Application number: 2026/91307	
What is the application for?:	Erection of two storey side extension with dormer
Address of the site or building:	46, Kingsley Crescent, Birkenshaw, BD11 2NL
Postcode:	BD11 2NL

User comments

Existing Elevations

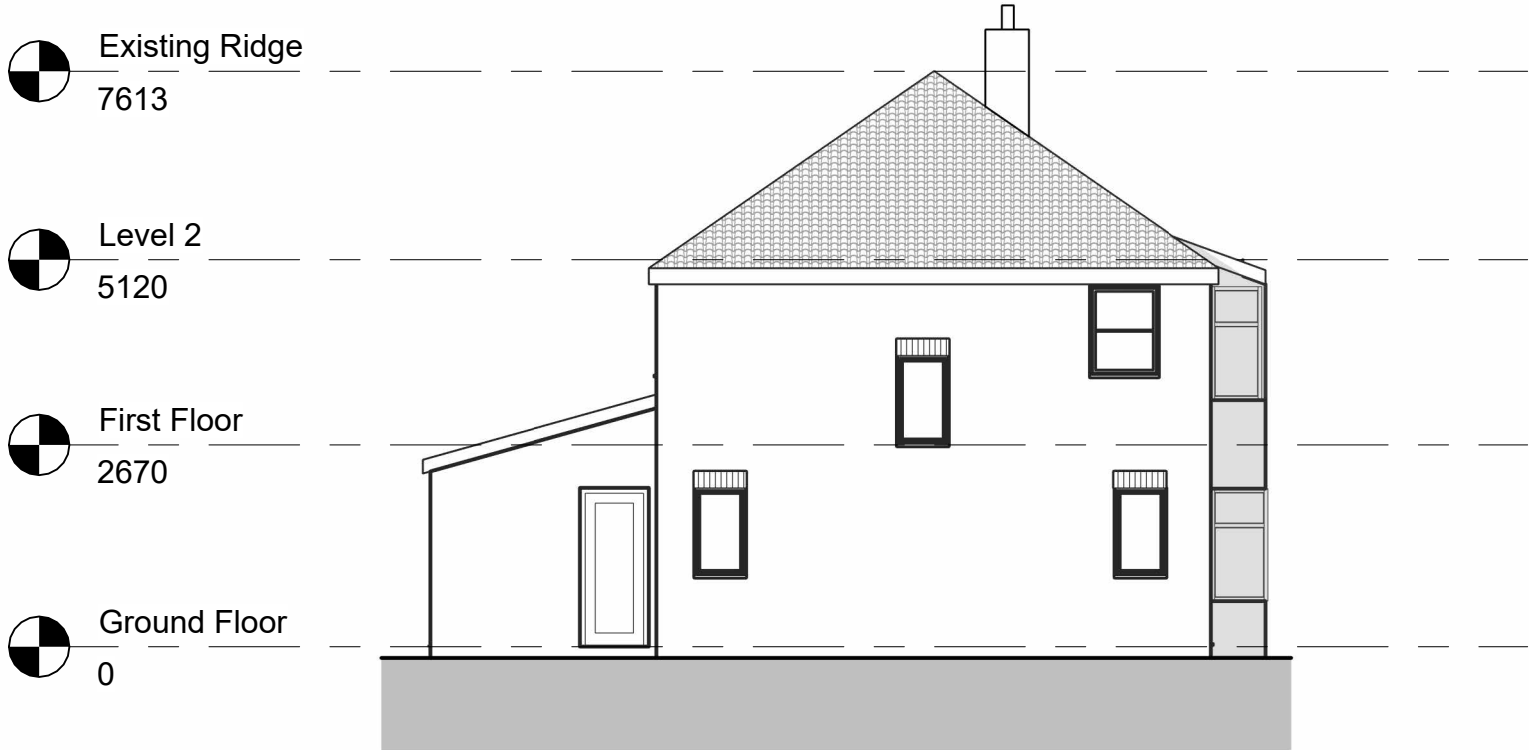
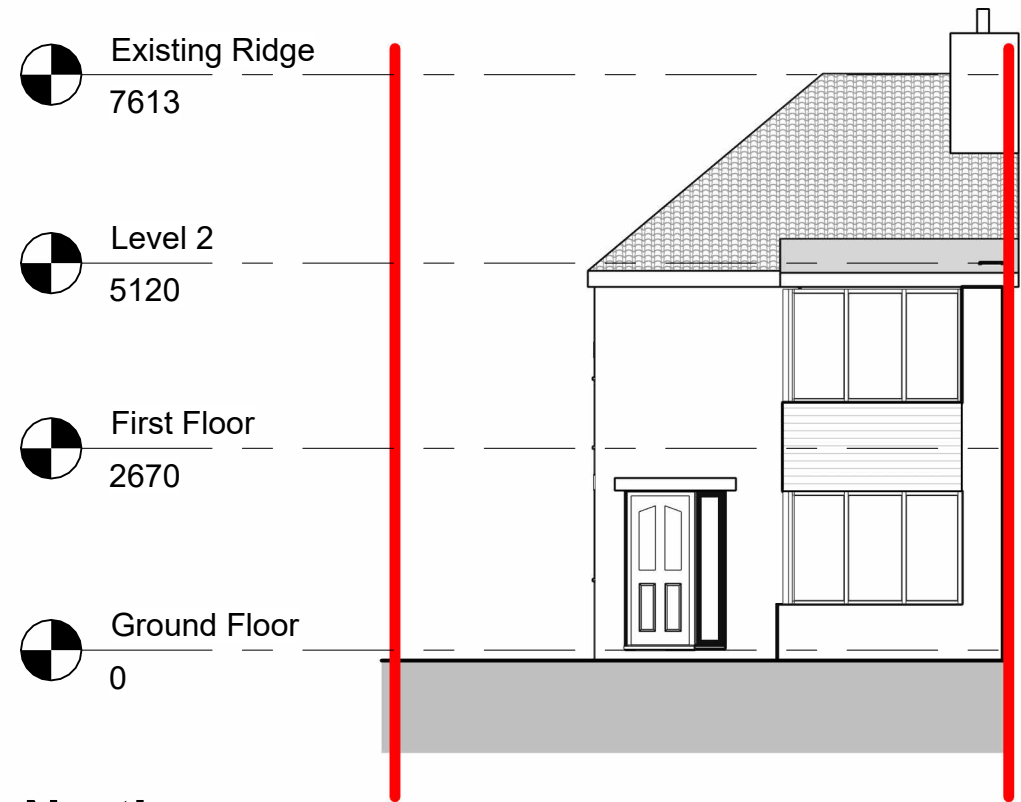
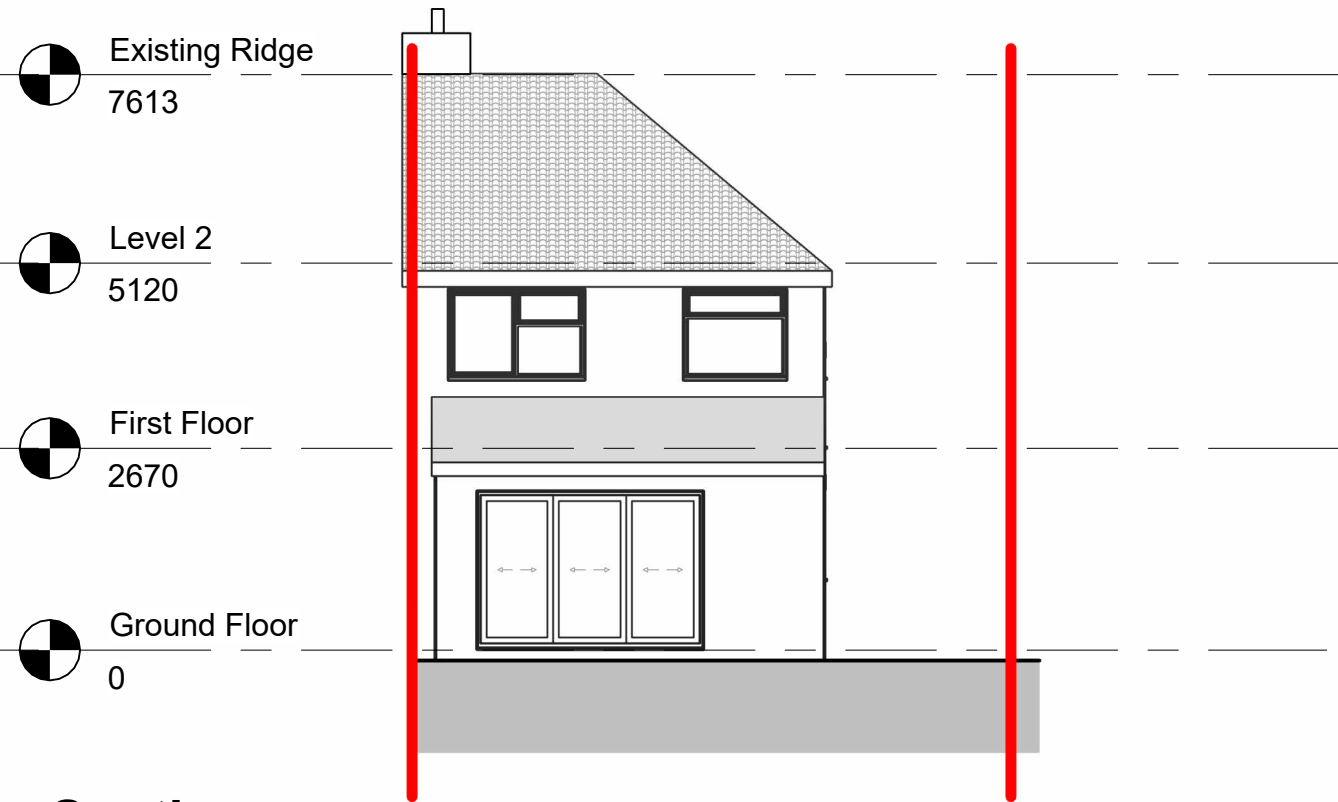
Type of comment: A general comment	
Do you wish your comments to be published on the website anonymously?	Yes
The planning application documents that have been submitted are not accurate. This property has already been extended at the rear, this extension has a flat roof and extends about 4m from the property into the back garden, but it is shown in this planning application as being inline with the extension on the adjacent and having a sloping roof. I cannot find an approved application for the 4m extension with a flat roof. If the property owner has built this without approval he may disregard any future planning decisions and build either without planning consent or to building regulations. The existing extension can be seen clearly from a car park at the rear of the property.
